Our Case Number: ABP-314724-22

**RE: SUBMISSION ON THE METROLINK ON BEHALF OF WYNN'S HOTEL, 35-39
ABBEY STREET LOWER, DUBLIN 1, D01 C9F8**

Project Title	Project Metrolink – Wynn's Hotel Dublin	From	Robert Coughlan, PUNCH Consulting Engineers
Project No	222266	To	An Bord Pleanála
Subject	Technical Submission to Railway (Metrolink–Estuary to Charlemont via Dublin Airport) Order 2022 at – Wynn's Hotel Dublin, 35-39 Abbey Street Lower, North City, Dublin 1, D01 C9F8	Cc	
Date	12-01-2023

2.0 Technical Observations

Drawing Title: **Figure 20.16 Settlement Contours Sheet 26 of 30**

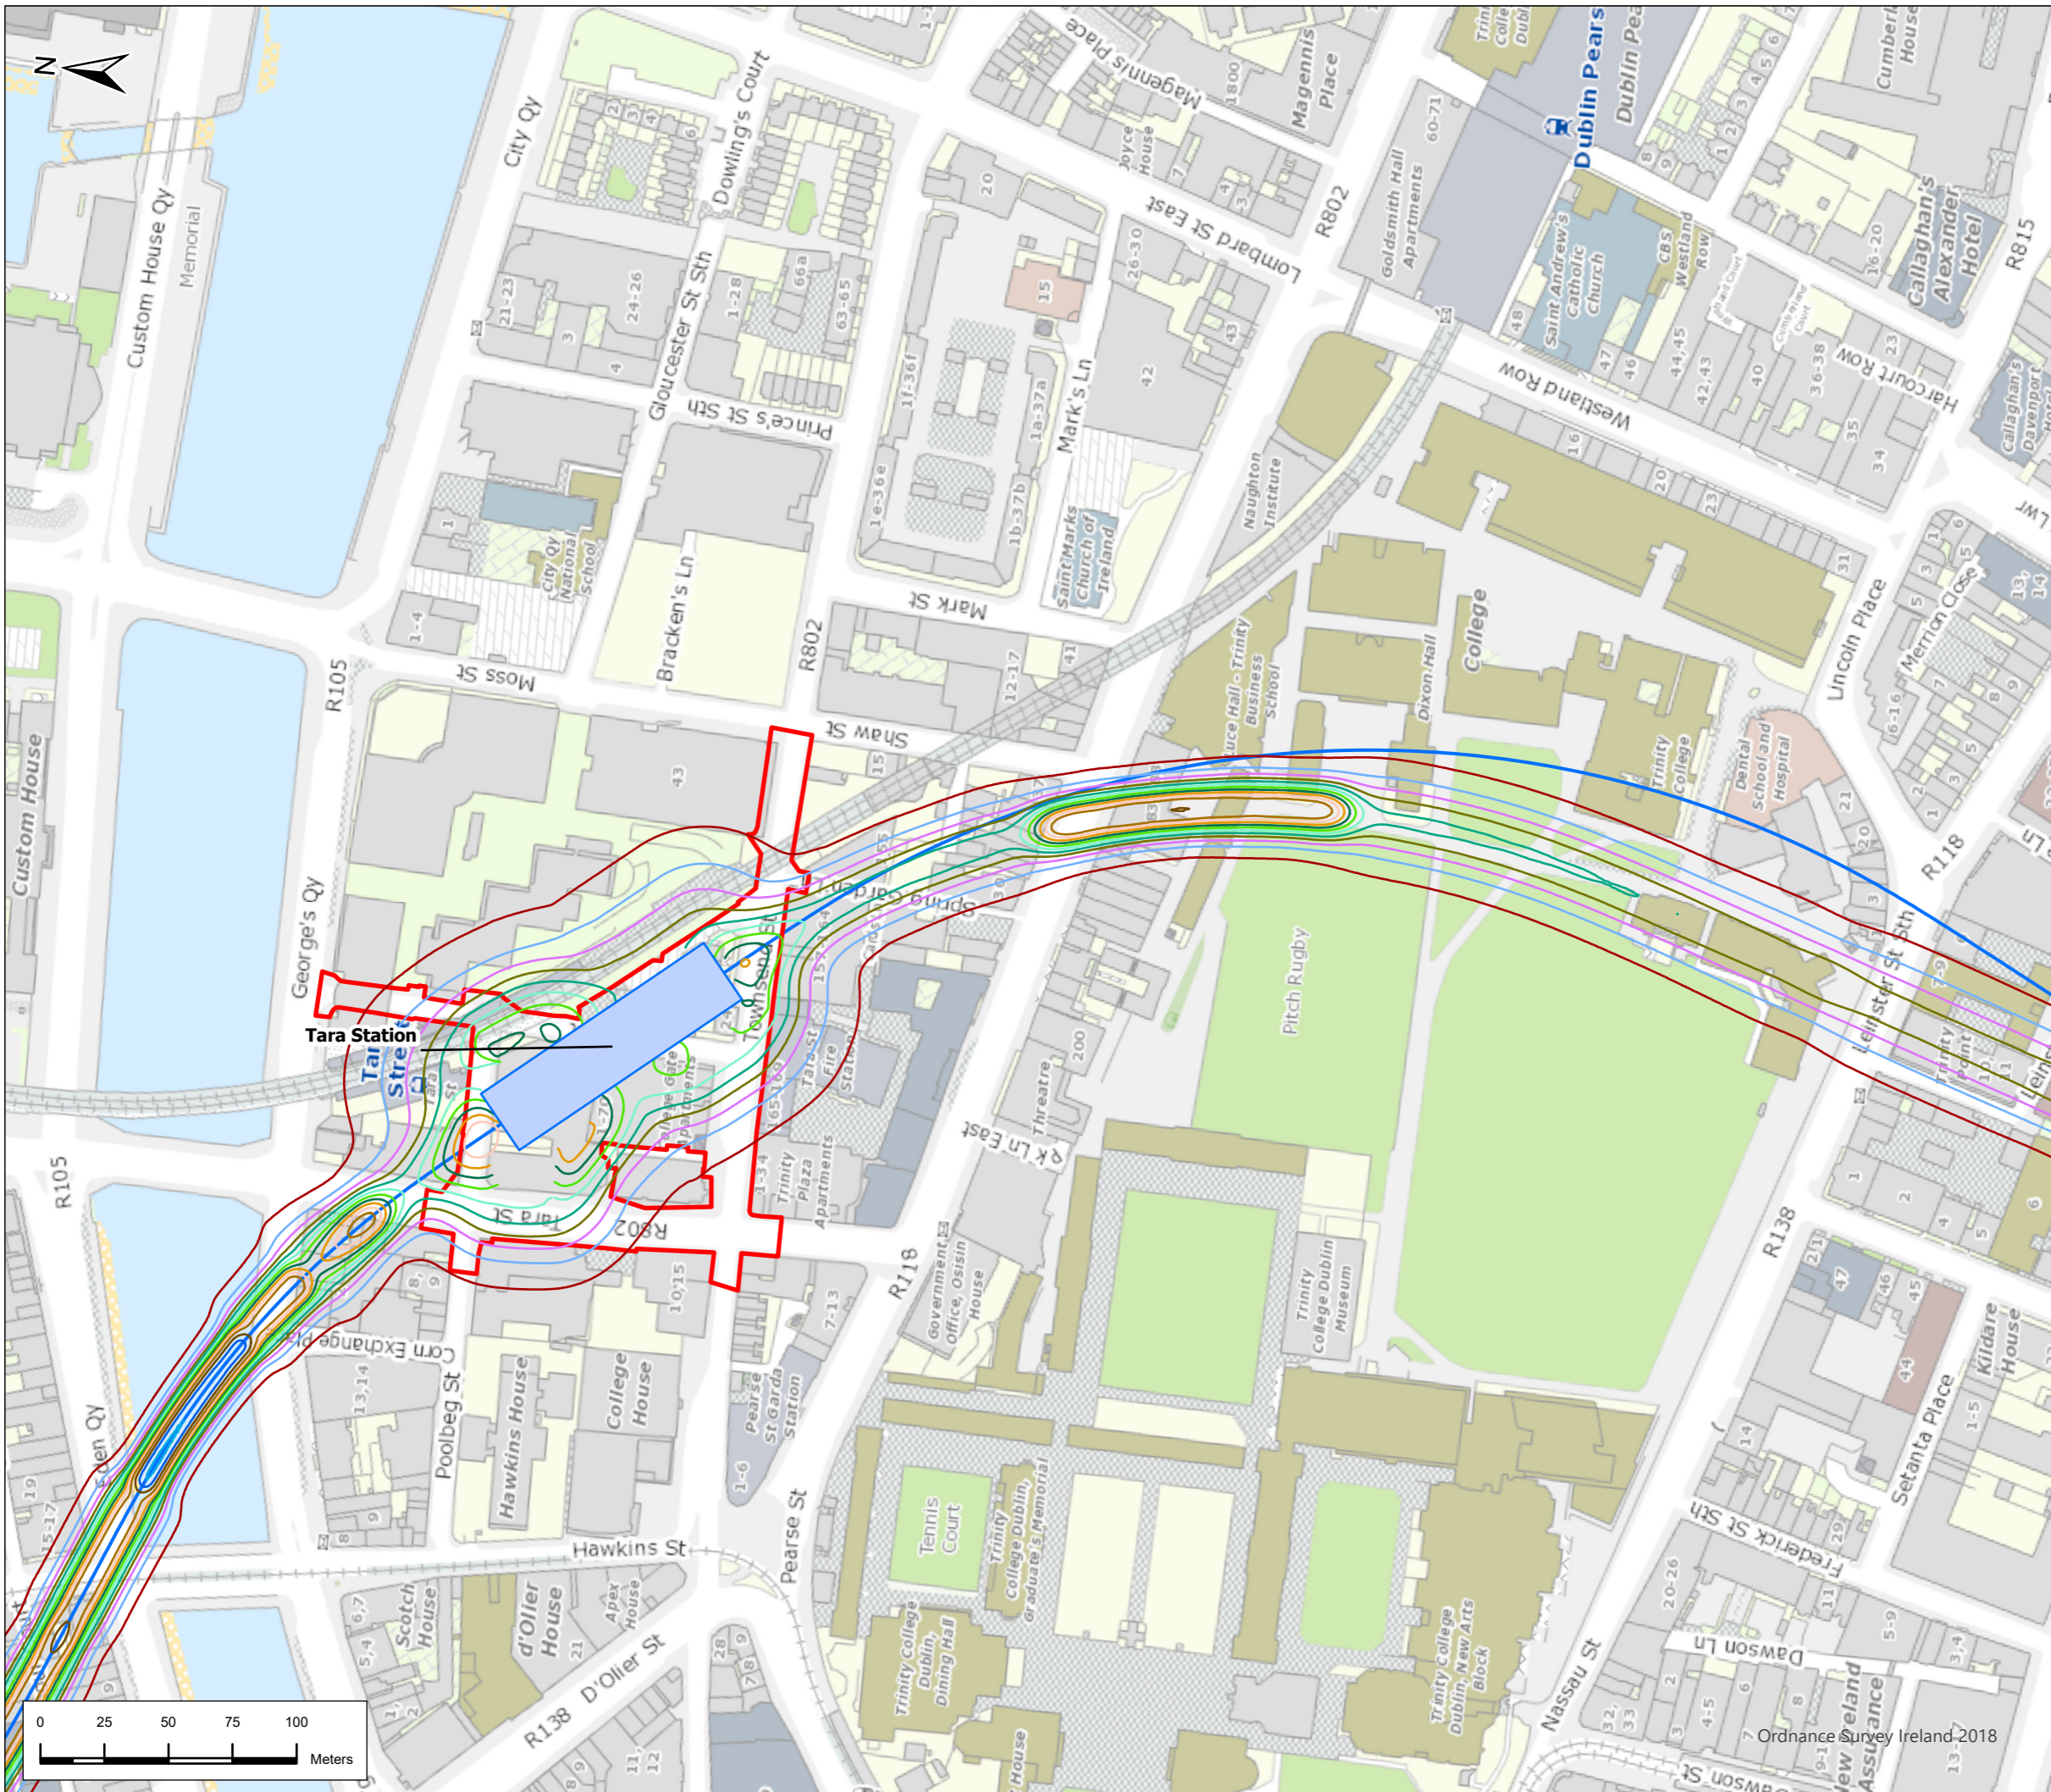
- i) The predicted settlement is a concern from available information on <https://www.metrolinkro.ie/>. The settlement contours on Figure 20.16, sheet 26 of 30 (Refer to Appendix B), suggest settlement of 40-45mm in the calculated settlement trough. We request details from TII on how they established this deflection data. The building is a Protected Structure and over 170 years and TII must recognise this.
